PLANNING CONSULTATION RESPONSE

Application No	2026/0188
Proposal	Erection of 2no. extensions to the existing cricket clubhouse with associated hard and soft landscaping
Address	Higham Cricket Club, Royd Lane, Higham, Barnsley, S75 1PH
Date of Consultation Reply	15/04/26
Consultee	Highways DC

Drawing Title
Proposed Site Plan

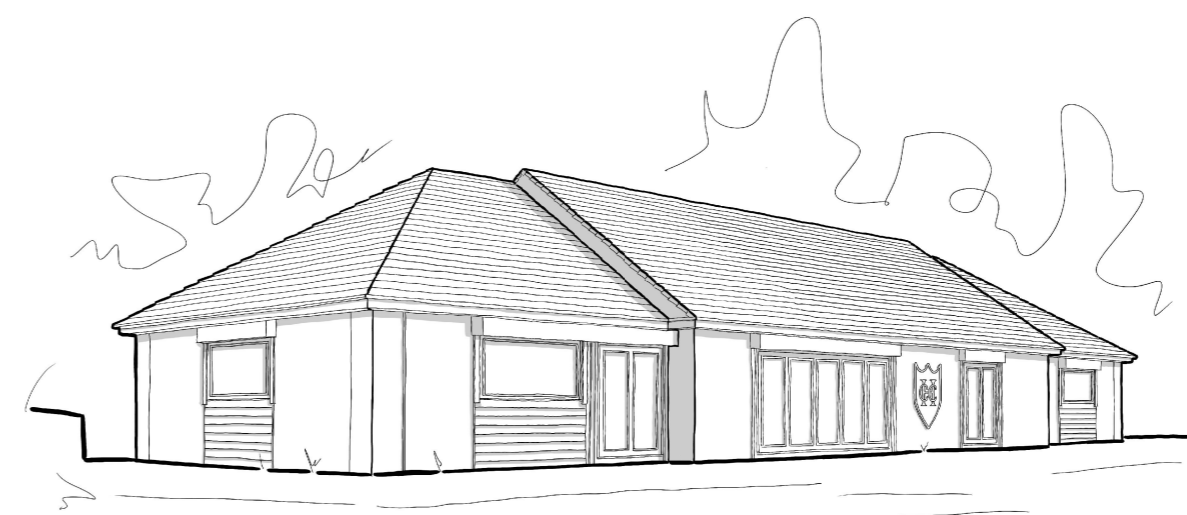
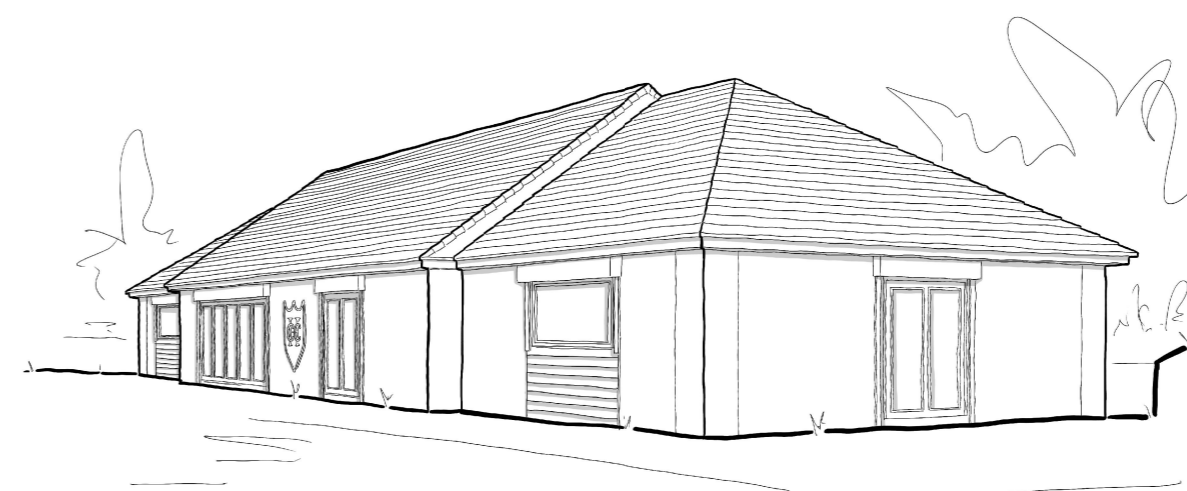
The built-out car park appears to be constructed to the 2016/0854 approval, with two car parking spaces being provided. These spaces are retained in this application and whilst the off-street parking provision is likely to be significantly below the demand on match days and when functions are occurring, it is accepted that this application is unlikely to exacerbate the issue. During a site visit it was apparent that the area was used for storage but, given the lack of off-street parking, it is important that this space is retained for vehicular parking. An appropriate condition is therefore included below.

The parking/manoeuvring facilities, indicated on the submitted plan, shall be surfaced in a solid bound material (i.e. not loose chippings) and made available for the manoeuvring and parking of motor vehicles prior to the development being brought into use, and shall be retained for that sole purpose at all times.
